M4 Junctions 3 to 12 Smart Motorway

Comments on the Examining Authority's Consultation Draft Development Consent Order

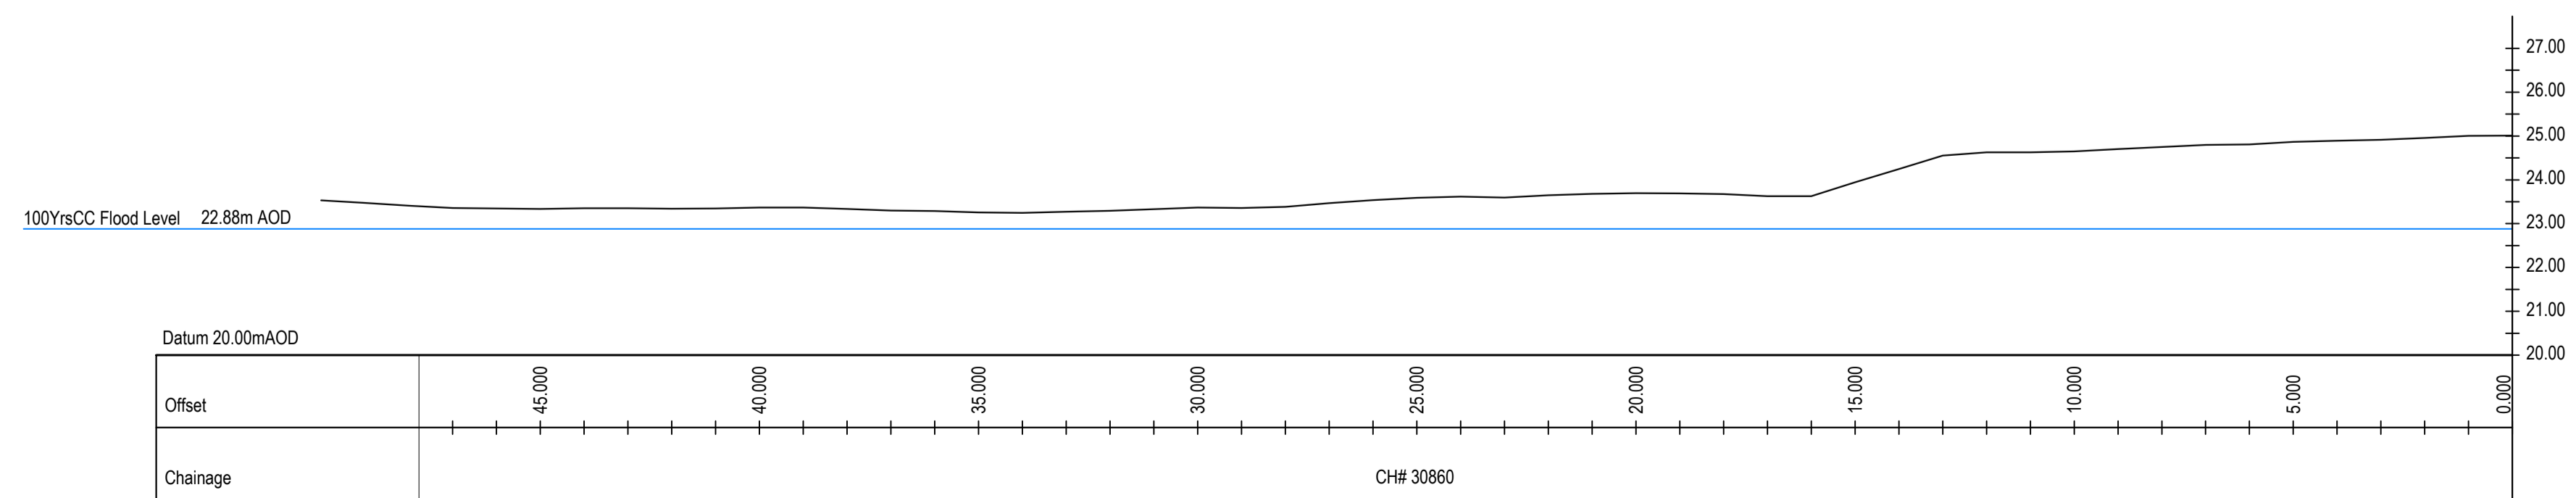
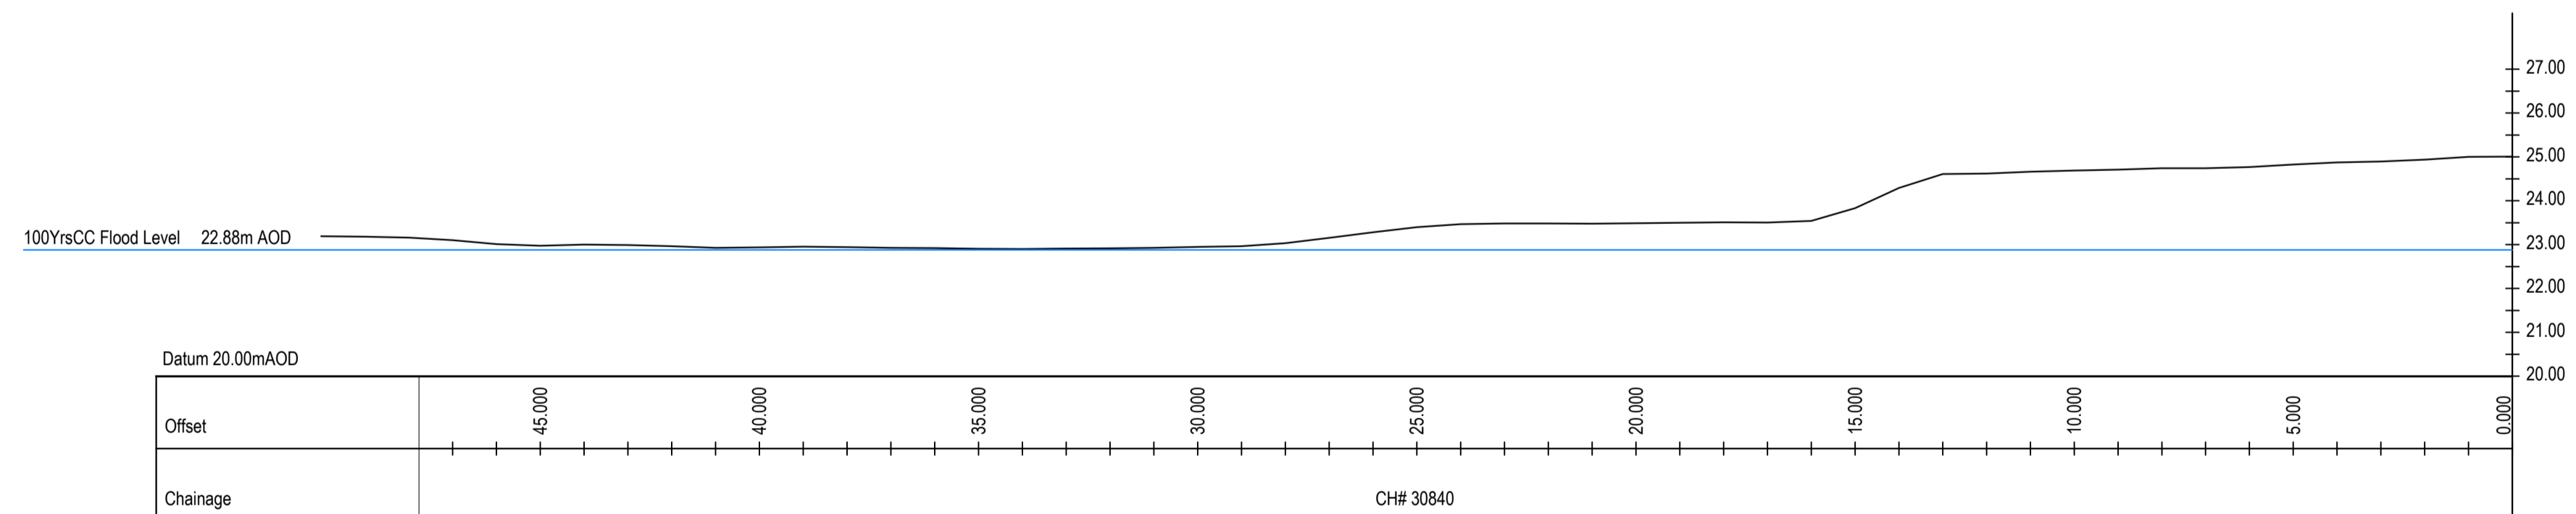
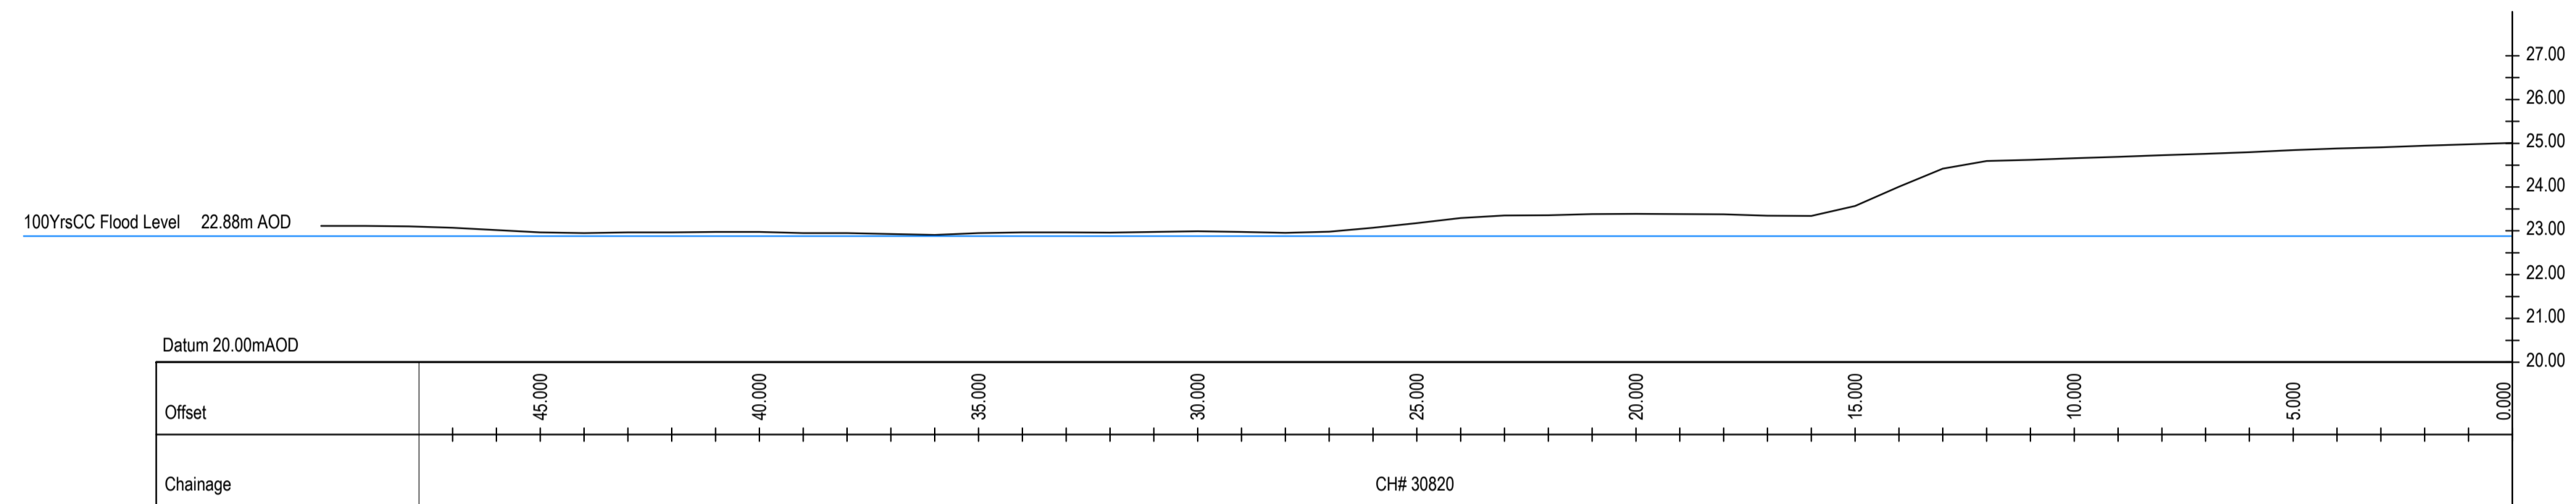
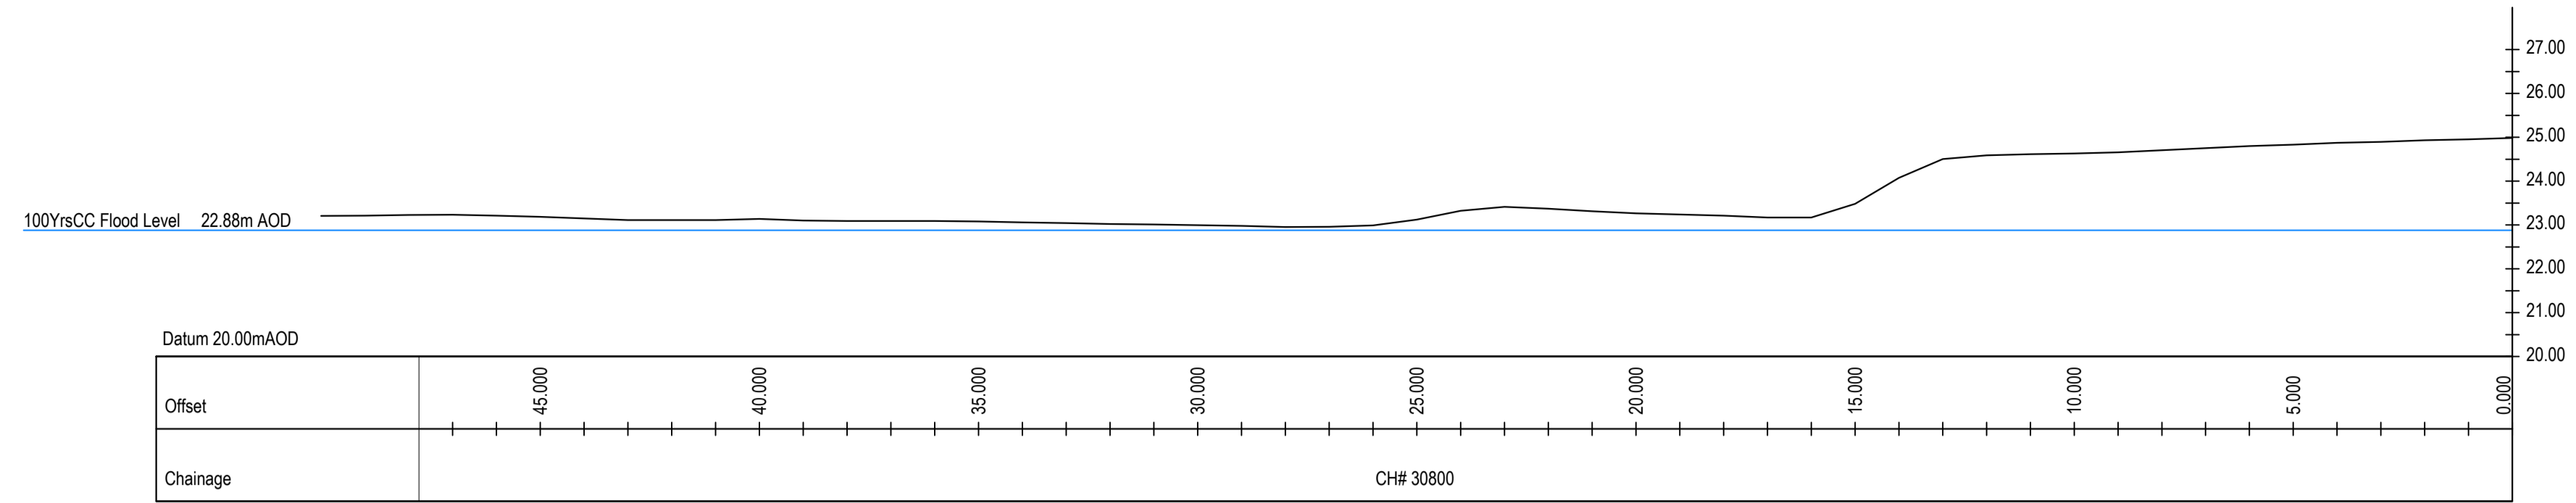
<p>flood risk in Flood Zone 3 (“flood compensation scheme”) has been submitted to and approved in writing by the Secretary of State, following in consultation with the Environment Agency and the relevant planning authority authorities.</p> <p>(2) The flood compensation scheme must ensure that compensation works:</p> <p>(a) are carried out in accordance with the outline flood compensation scheme shown on drawing [TR010019-2.3-v-20] sheets 1 to 13;</p> <p><i>ExA Comment: Does this reference need to be checked?</i></p>

<p>15. Schedule 2 - Part 1 (Amendment & Comment)</p> <p>23.—(1) No scheduled works within Flood Zone 3 as shown on annex H to the flood risk assessment are to commence until a detailed scheme of compensation works for the effects of the authorised development upon</p>	<p>26. Highways England can confirm that the drawing reference in sub-paragraph (2)(a) is correct and that the square brackets can be removed.</p>
